WALLARAH 2 COAL PROJECT

Amendment to DA SSD-4974 Response to DP&E

**WALLARAH 2 COAL PROJECT
AMENDMENT TO
DEVELOPMENT APPLICATION SSD-4974**

**RESPONSE TO DEPARTMENT OF
PLANNING & ENVIRONMENT**

Client	Project	Title	Original Size	Drawing No:	Rev:
WYONG COAL	WALLARAH 2	CREEK CROSSING BRIDGE PLAN	A3	22-17704-C350	B

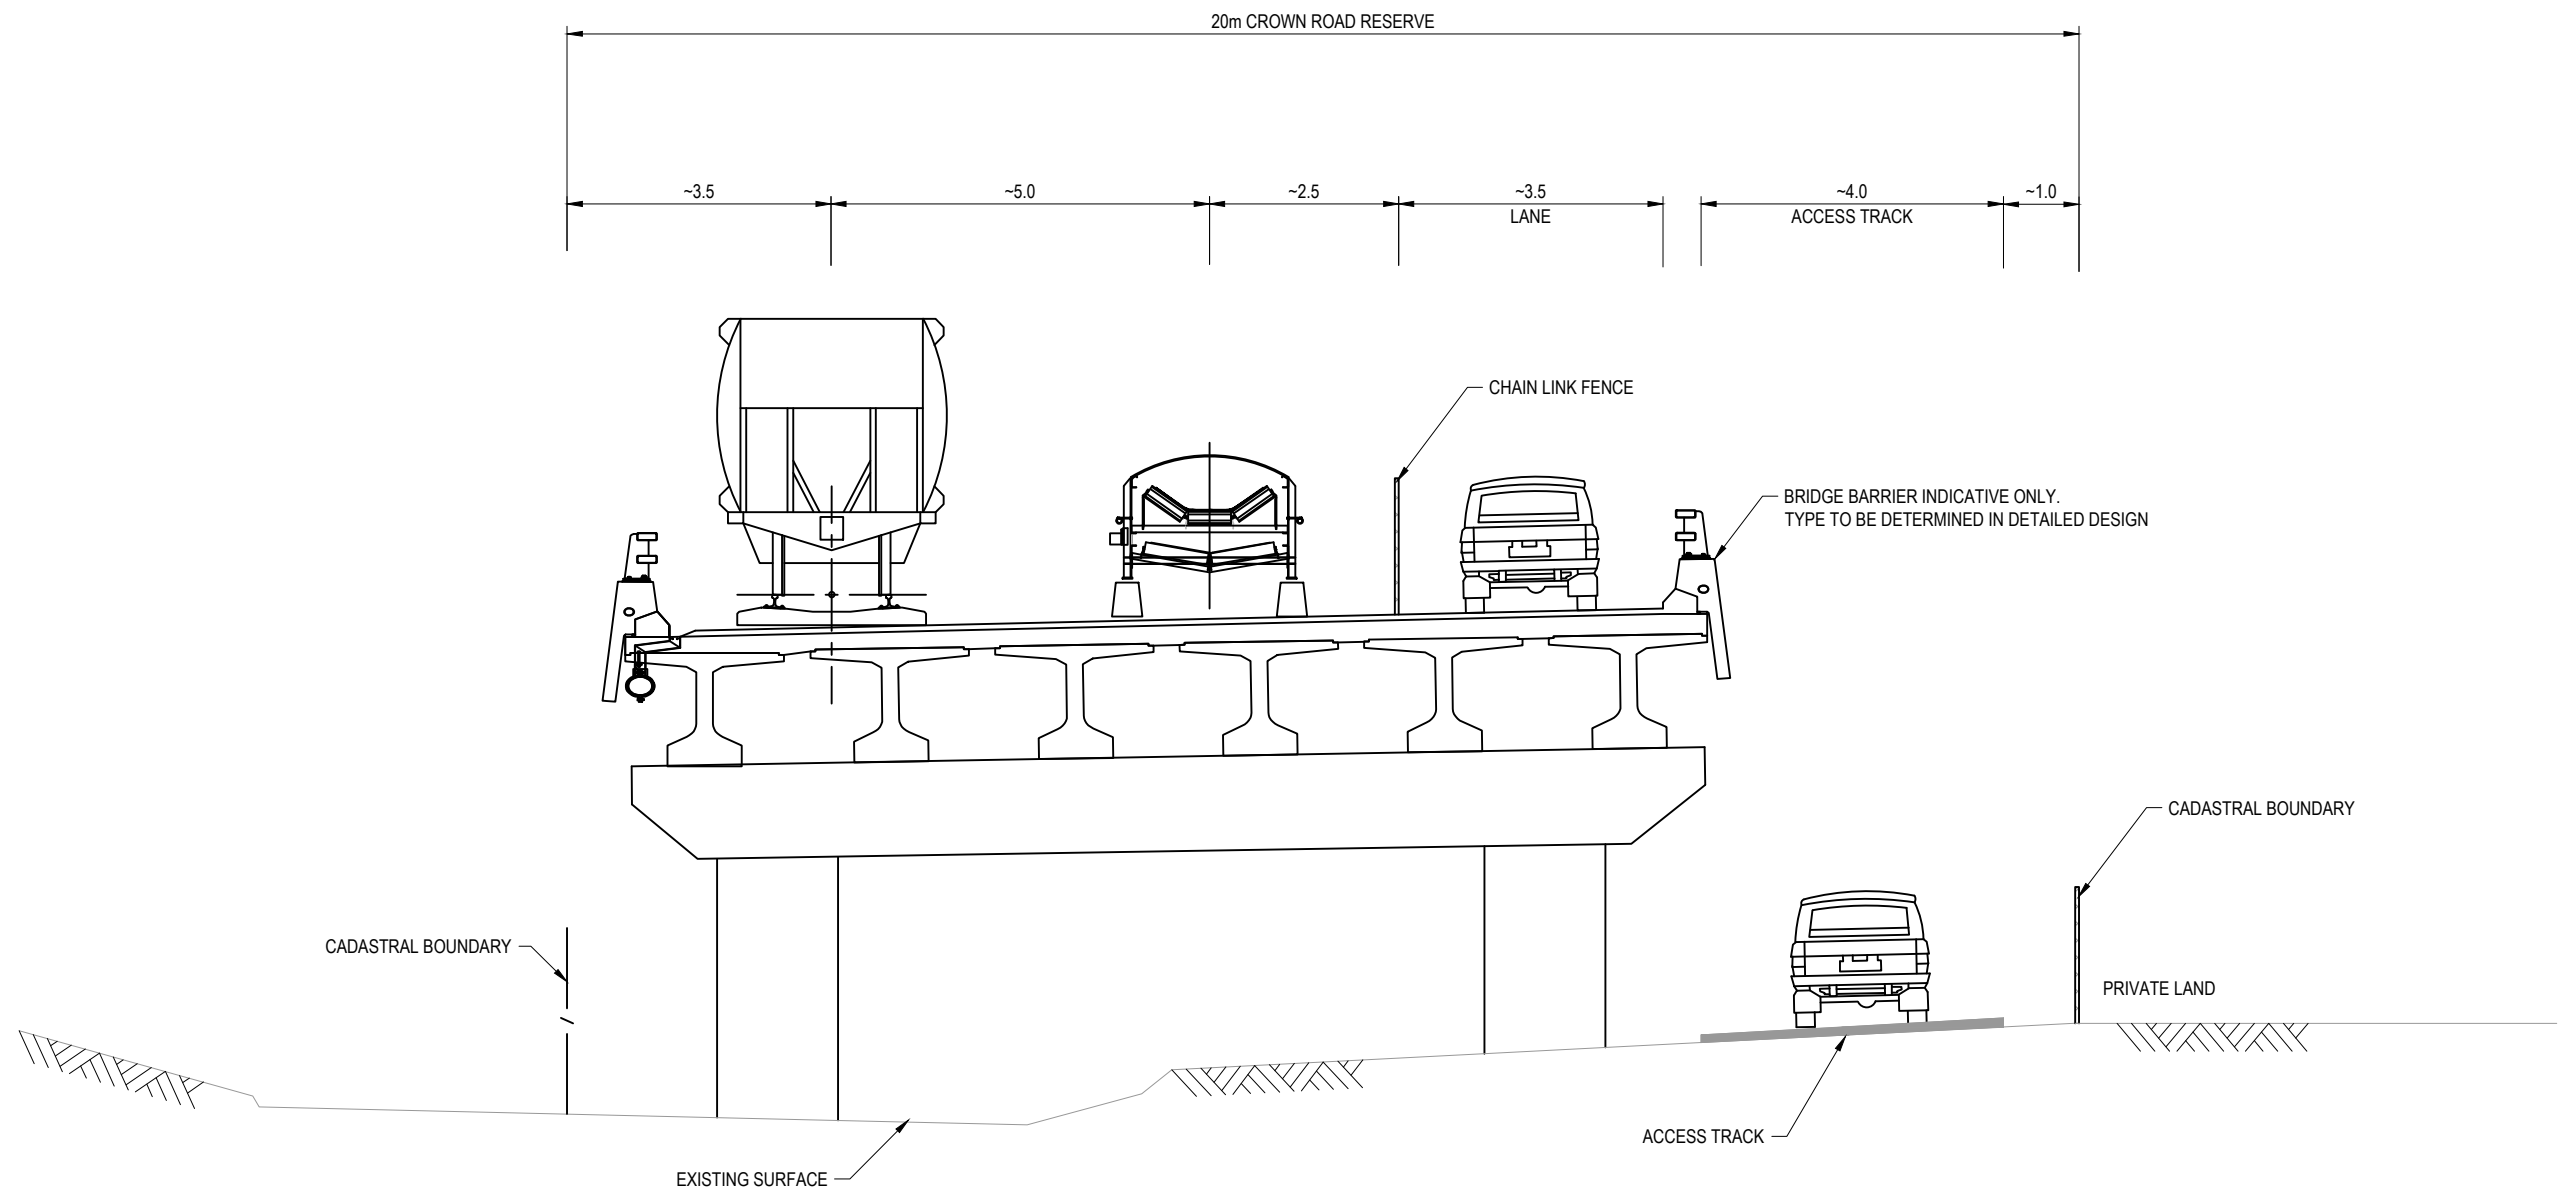
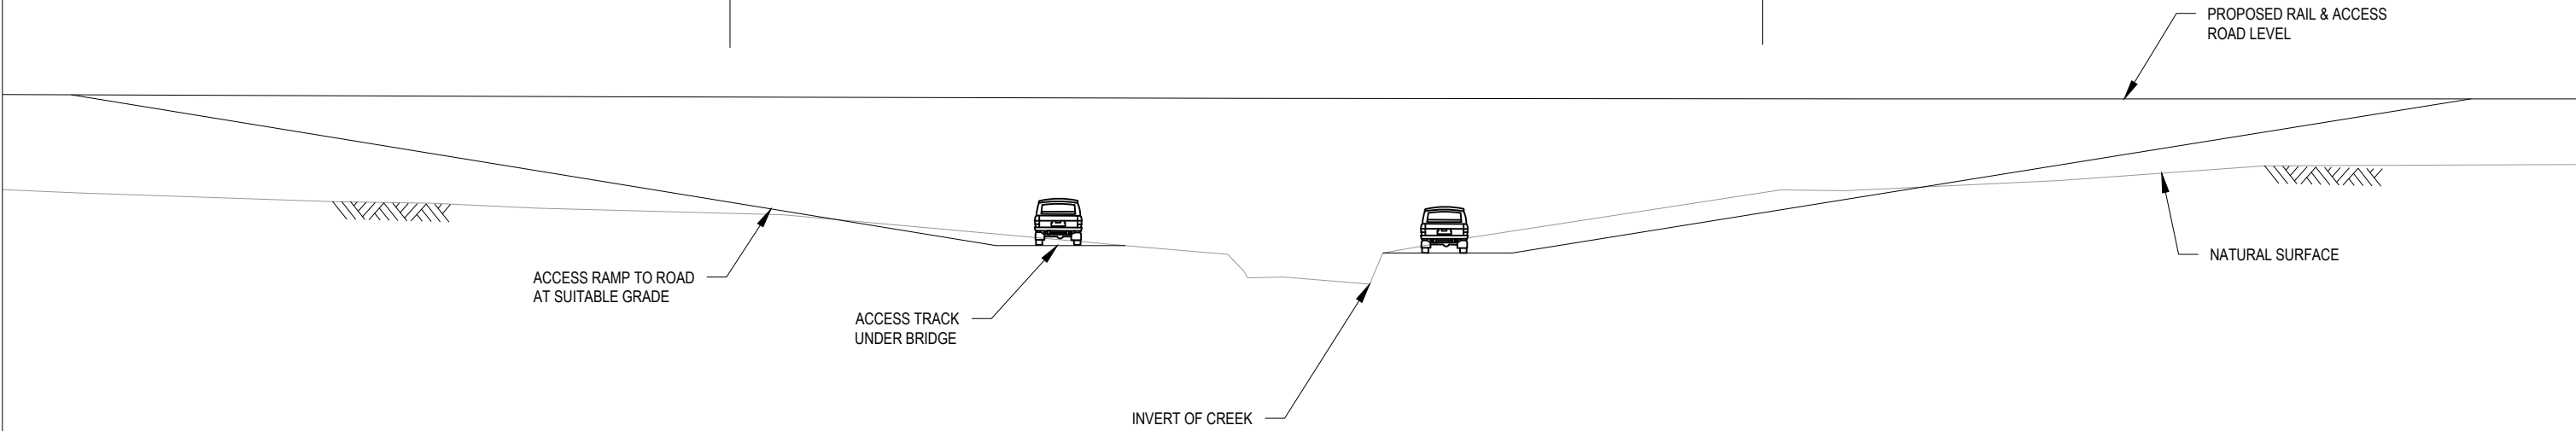
3. *The submission suggests that the EIS and Amended DA does not comply with this requirement. There are no appropriate drawings showing how Darkinjung's existing access will be maintained in relation to the construction of the bridges in the vicinity of Spring Creek or how that access will be maintained with the proposed changes in levels of the land.*

Finalisation of detailed infrastructure design necessarily occurs post approval and in detailed consultation with stakeholders, including relevant adjoining landowners. Similarly, detailed design of ancillary works will occur in concert with final infrastructure design.
